Online Comment

Application H16-0063-24
Location Nationwide Building Society 4 Hall Place Spalding PE11 1SA
Proposal Proposed Signage and ATM

Name Greg Watkinson
Address Conservation Officer

#	#			#		
#	#			#		
#	#			#		
LETTER DESCRIPTION				DATE		
E & PREFIX: G ce		DRAWING TYPE: PROPOSED EXTERNAL ELEVATION				
	SCALE @ A3: 1:100	DATE DRAWN: 31.10.2023	STATUS:	PROPERTY LOCATION CODE:	DRAWING REF NO:	REV.
	CHECKED BY & DATE: JNA	JOB REF:	PROPOSED	SP02	PR.00.E1	/

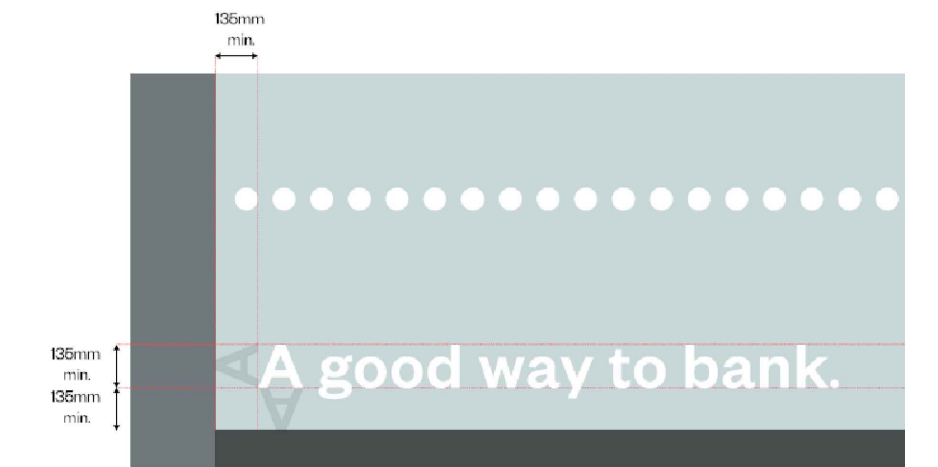
I wish to raise no objections to this proposal. Typically, internally illuminated signage would not be considered to be acceptable in a conservation area setting. However, in this instance, the extant signage is internally illuminated and the same is similarly featured within this proposal.

The proposed signage is appropriate, and considering the existing signage on neighbouring buildings supporting other businesses this is in keeping with the style and materials in the area
